## **SECTION 4.55(1A) MODIFICATION APPLICATION BUILDING R4B – SSD 8892218**

This modification application has been prepared by Ethos Urban on behalf of Lendlease (Millers Point) Pty Ltd, pursuant to section 4.55(1A) of the *Environmental Planning and Assessment Act 1979* (EP&A Act) to modify Development Consent SSD 8892218 relating to Building R4B Barangaroo South (the site).

R4B Floor Plan for Levels 48-63 - Proposed

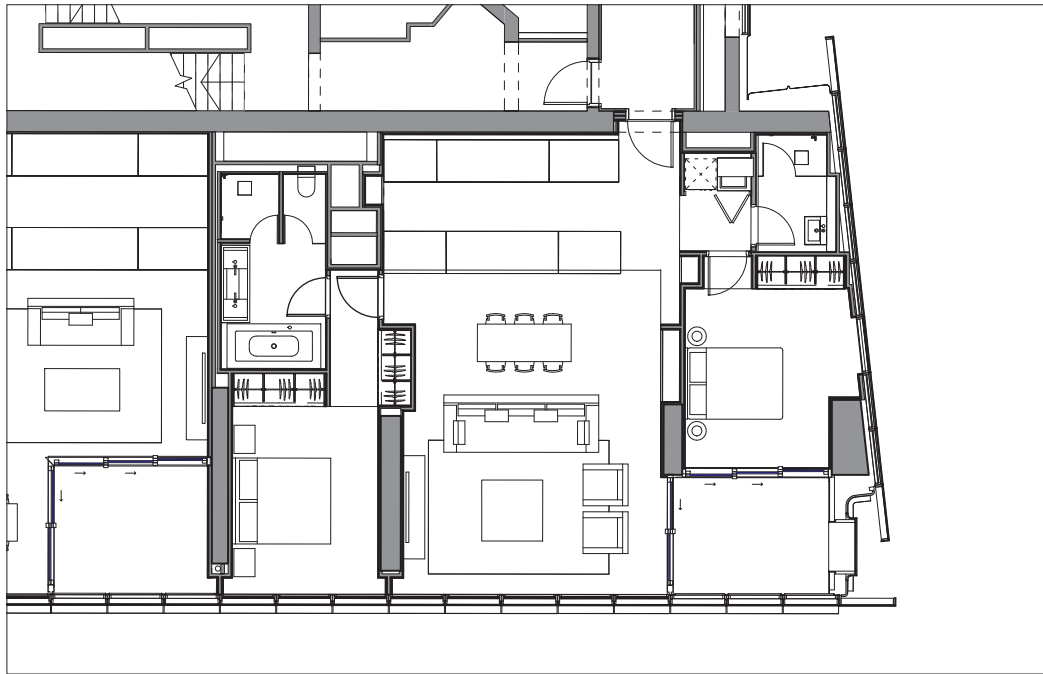
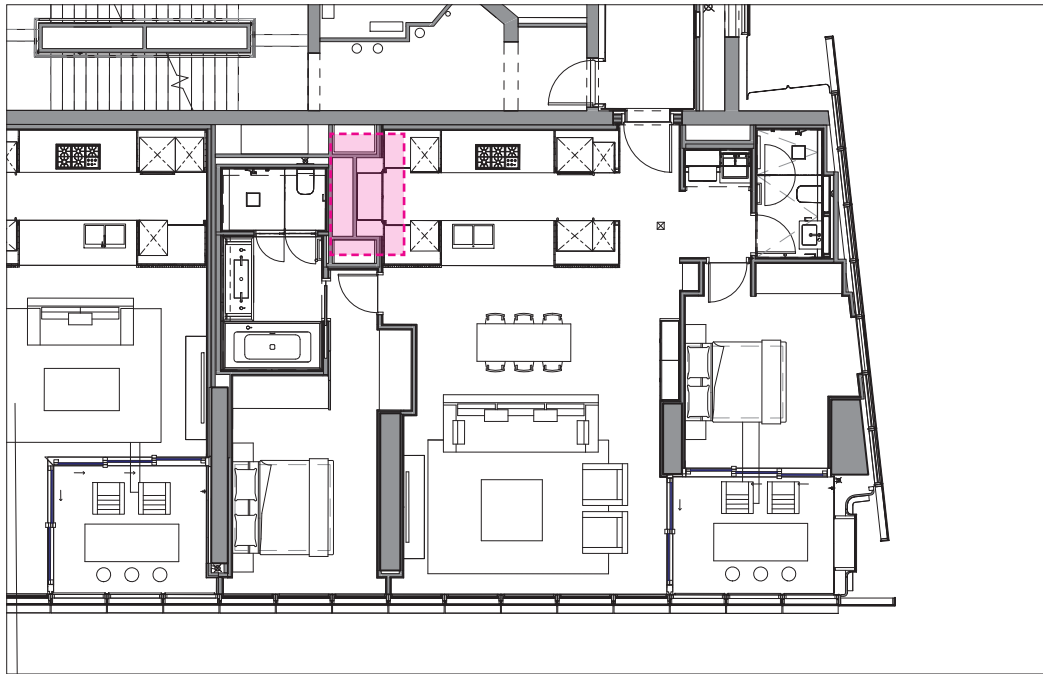
A minor reconfiguration of apartments type UB-03 on Level 48-62 is proposed to incorporate a cupboard to accommodate home automation utilities. This reconfiguration applies to 15 apartment and the change is illustrated in **Figure 1**.

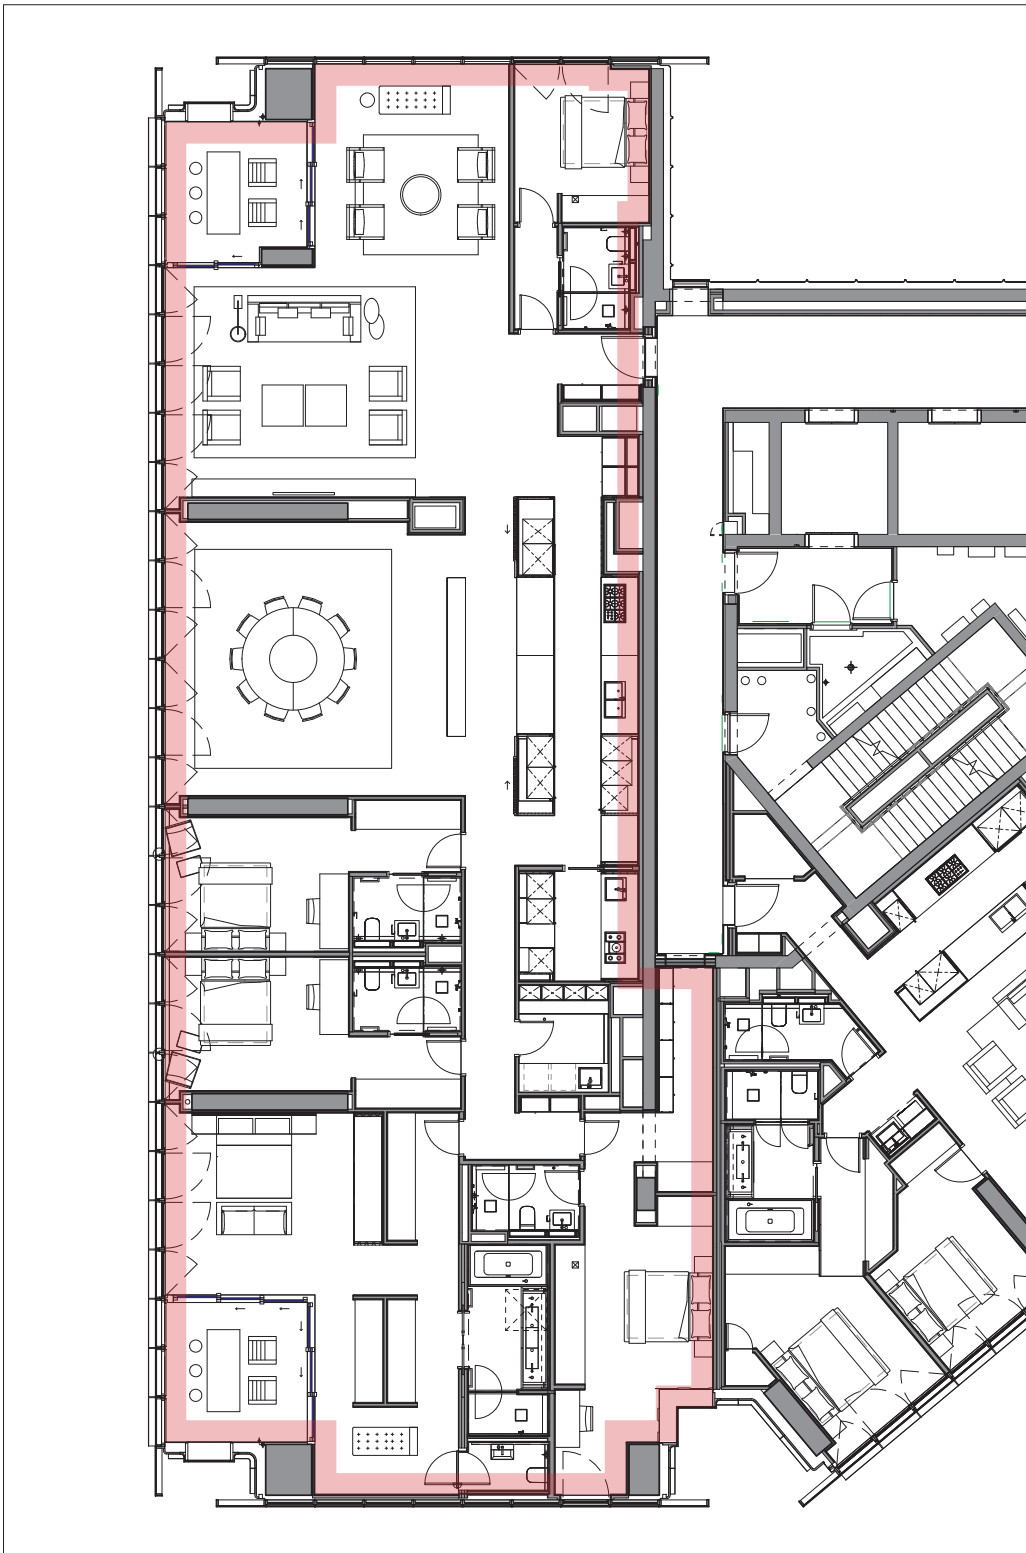
This modification seeks approval for the amalgamation of two 3-bedroom apartments on Level 59 in order to create one 5-bedroom apartment at that location. This amendment is proposed in response to a purchaser request. The proposed amalgamation is shown in **Figure 2**.

R4B Floor Plan for Level 64 - Proposed

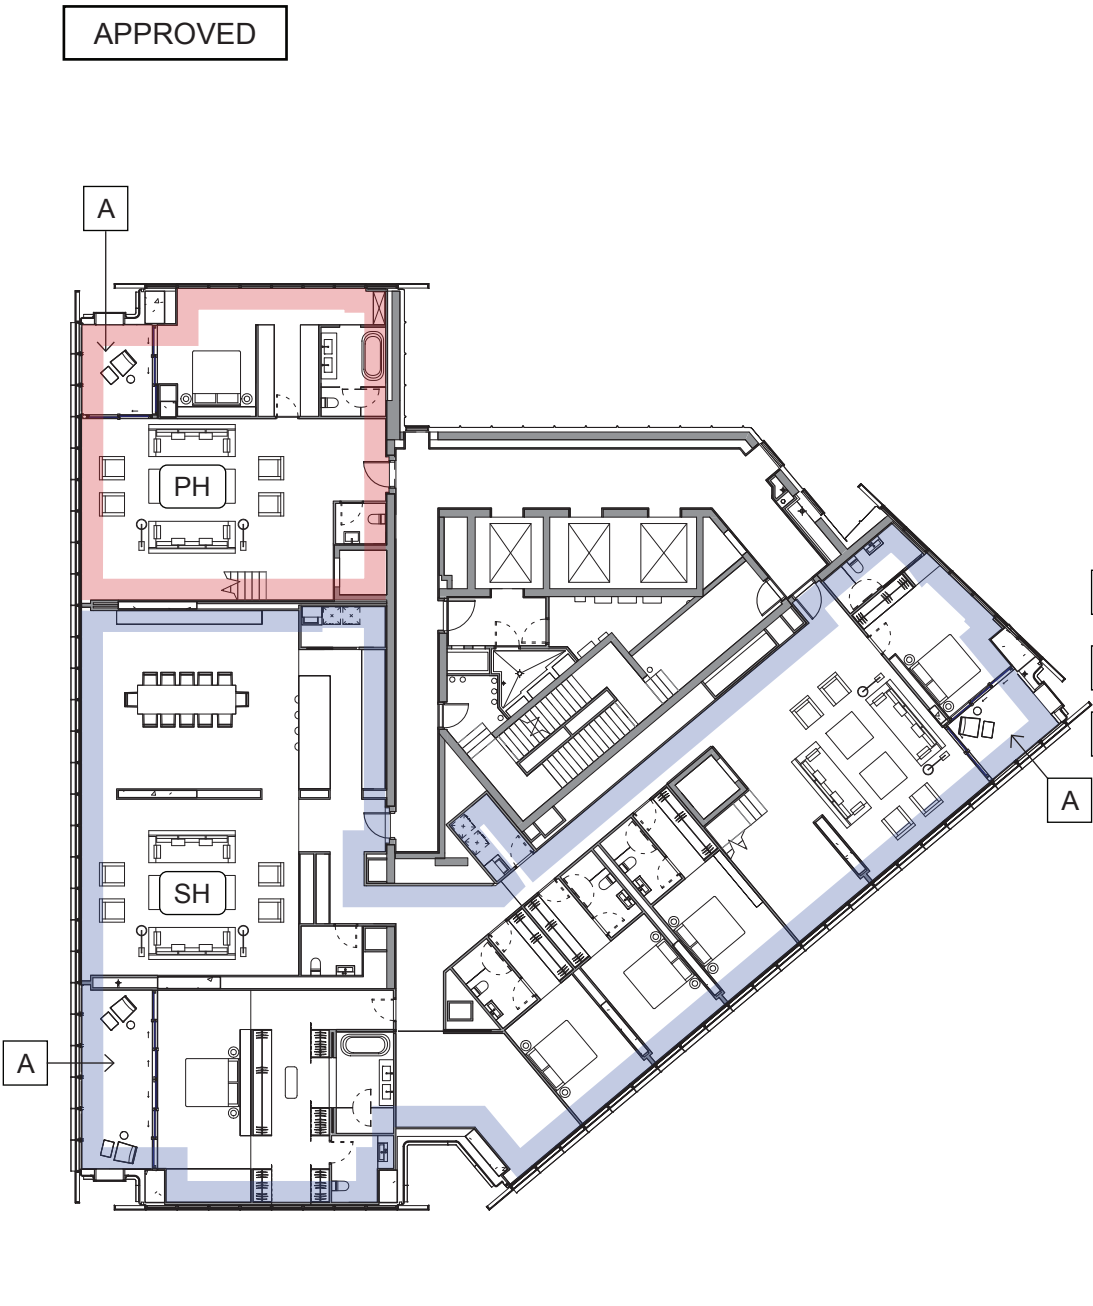
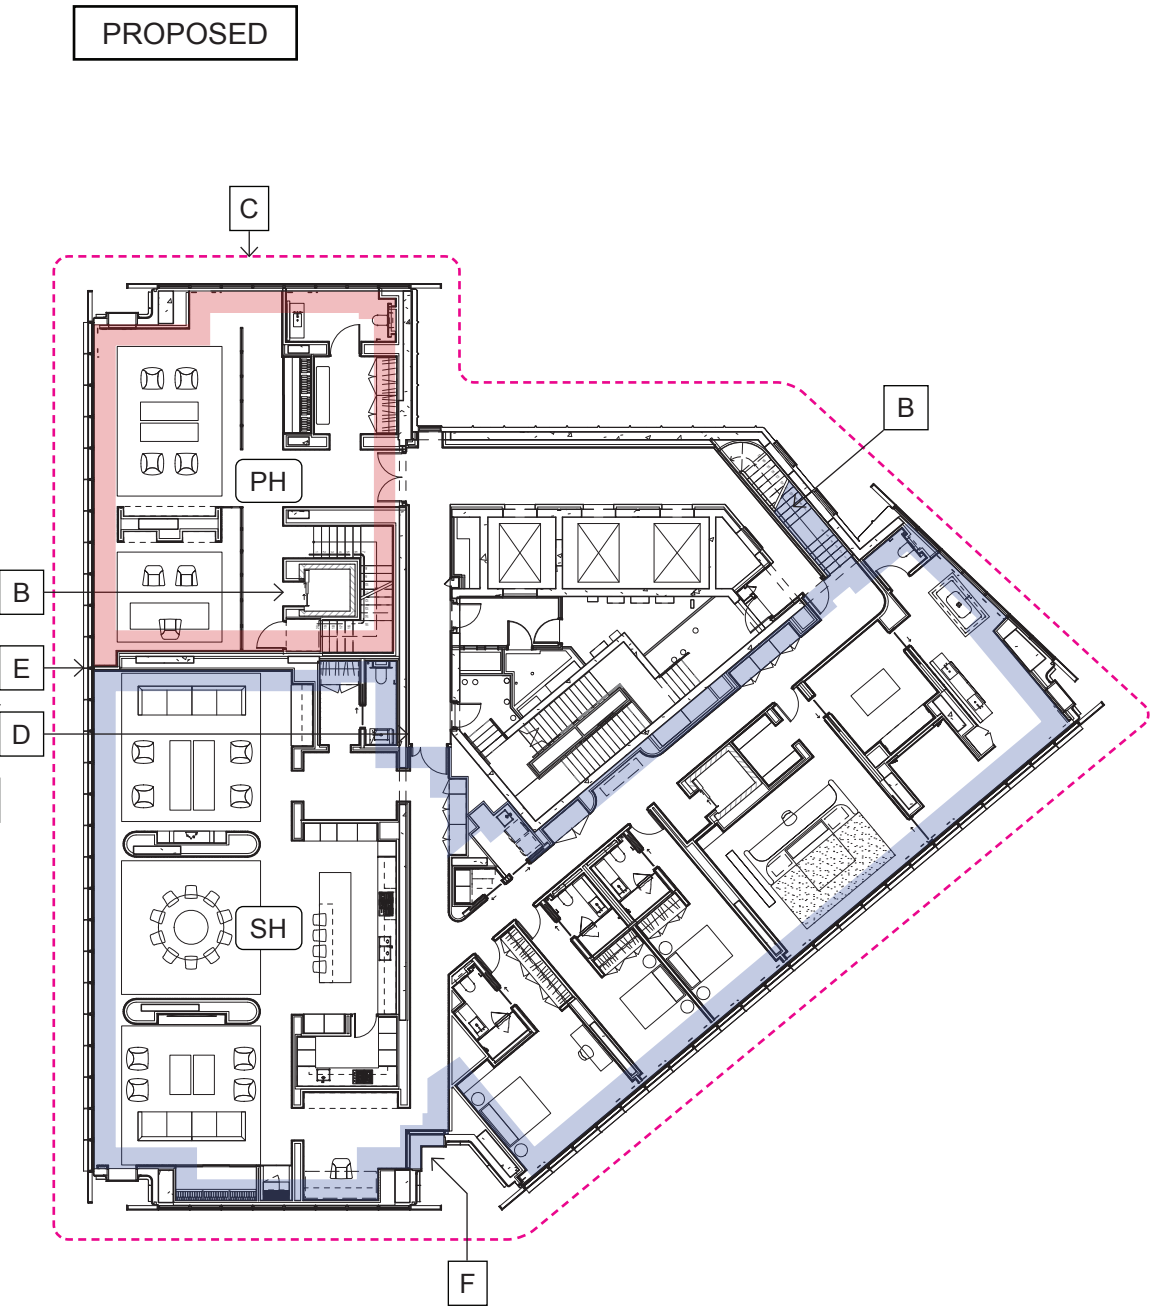
### Level 64

A reduction from 5 to 4 bedrooms, with relocation of master bedroom from north west to south west corner. Apartment entry door adjusted, removal of winter gardens and overall associated internal changes including stairs to Level 65. Apartment title amendment from SH 01 (Skyhome 01) to SH (Skyhome).

Internal reconfigurations including removal of a bedroom and apartment title amendment to PH (Penthouse).

R4B Floor Plan for Level 65 - Proposed

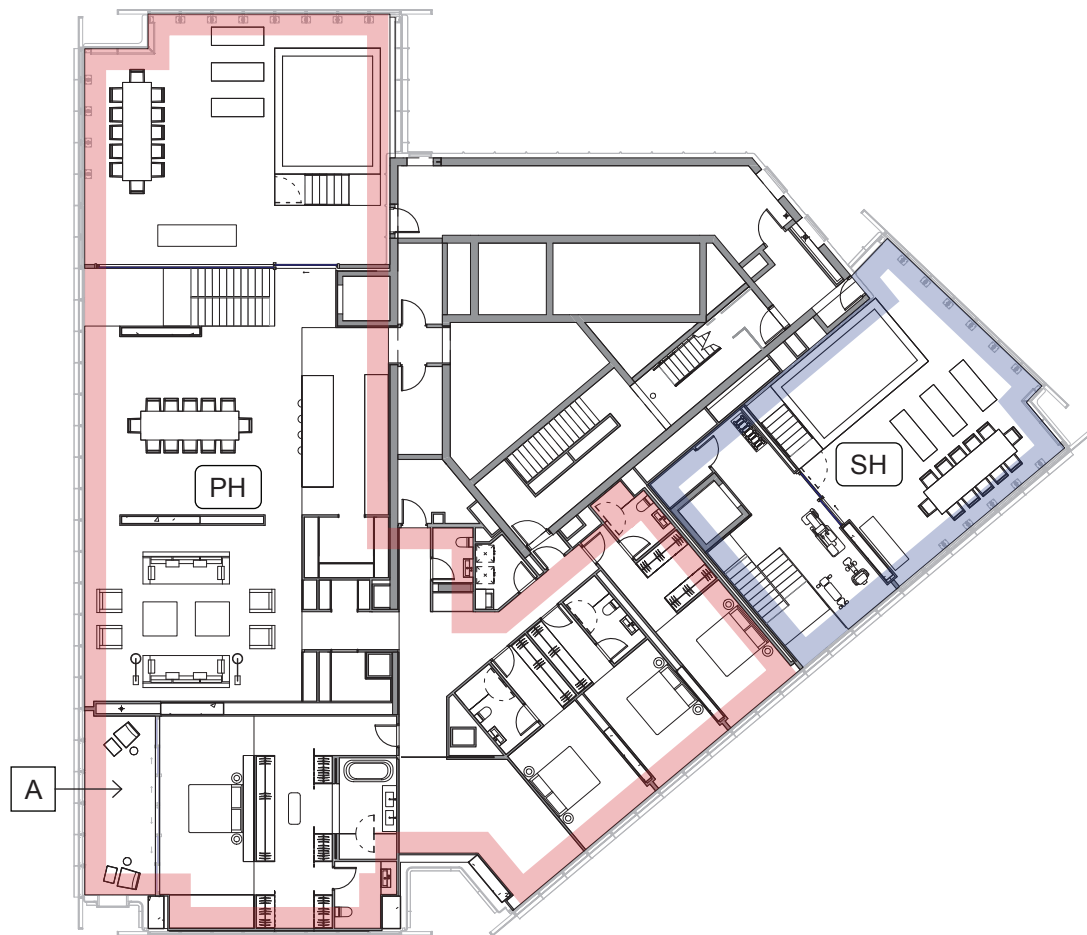
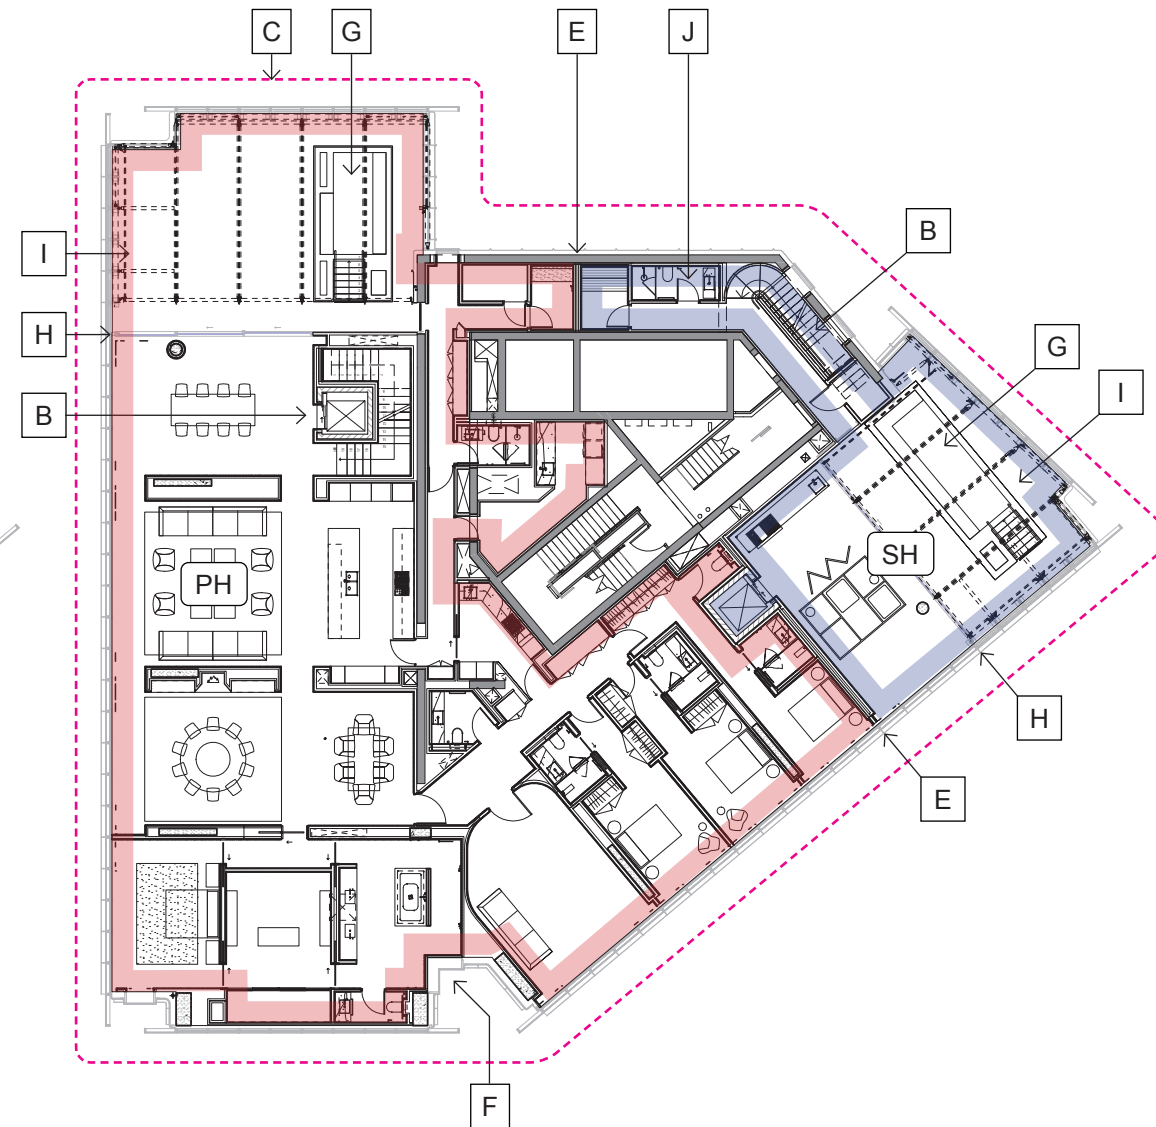
Internal reconfigurations, removal of wintergardens, reconfiguration of outdoor terraces. Associated apartment title adjustments to SH (Skyhome) and PH (Penthouse).

R4B Rooftop Floor Plan - Proposed

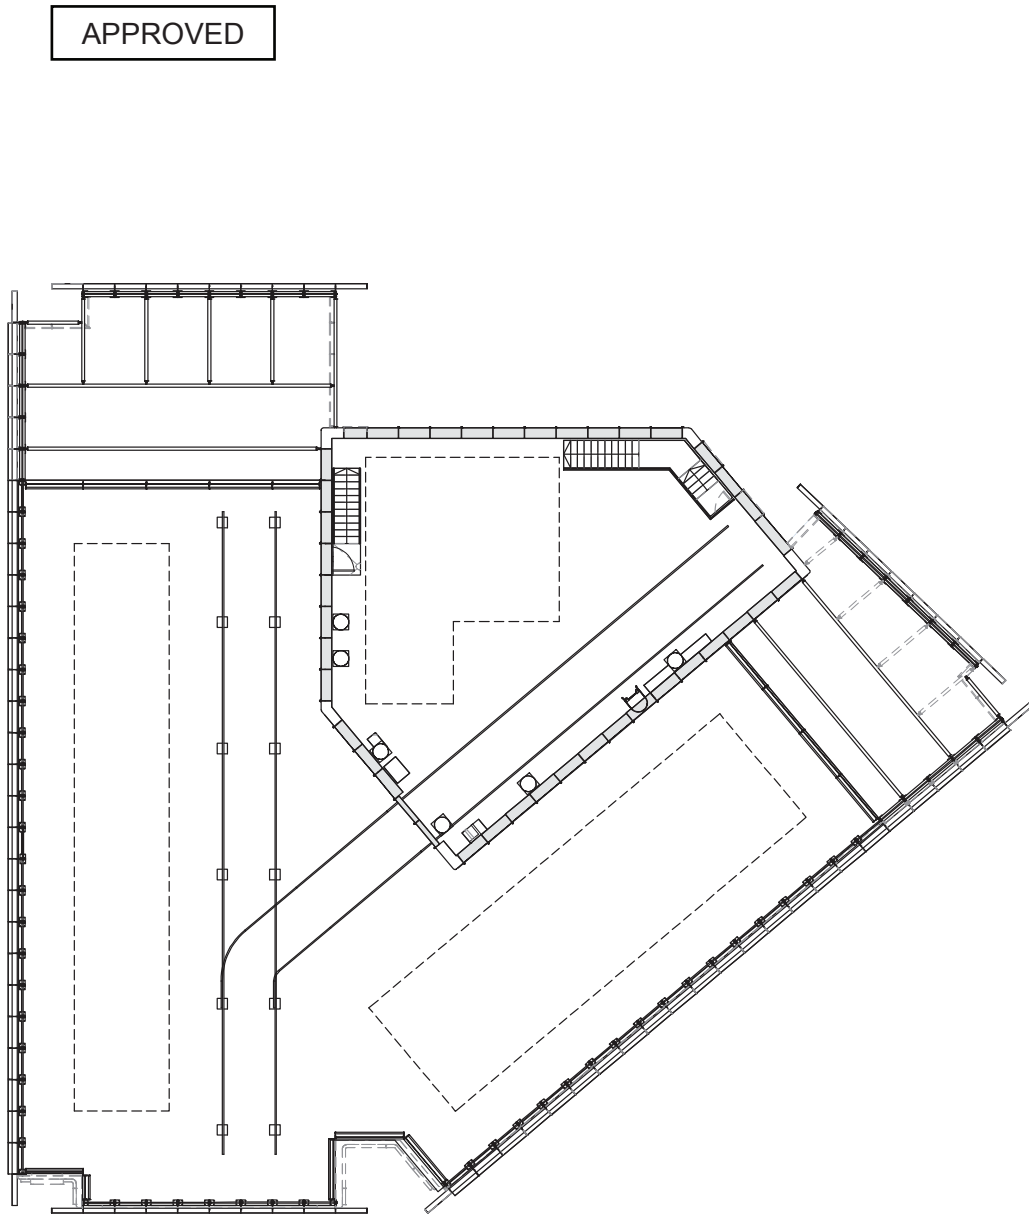
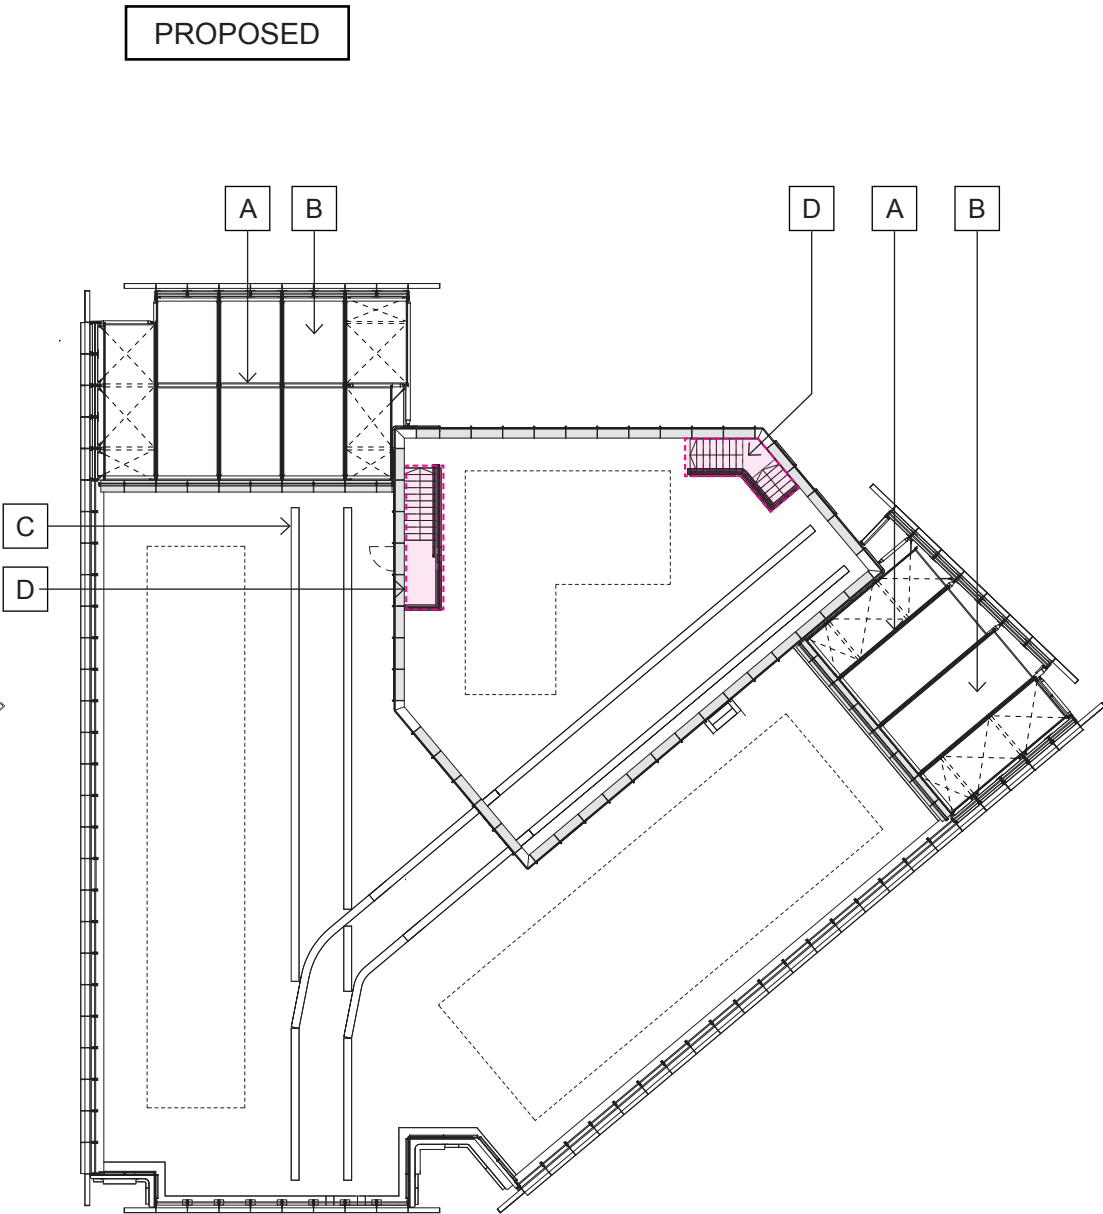
- Refinement of the double height steelwork design.
- Refinement of the sun shading above Level 65 outdoor terraces.
- Refinement of the building maintenance unit (BMU) rails and parking location.
- Revised upper roof stairwell voids.
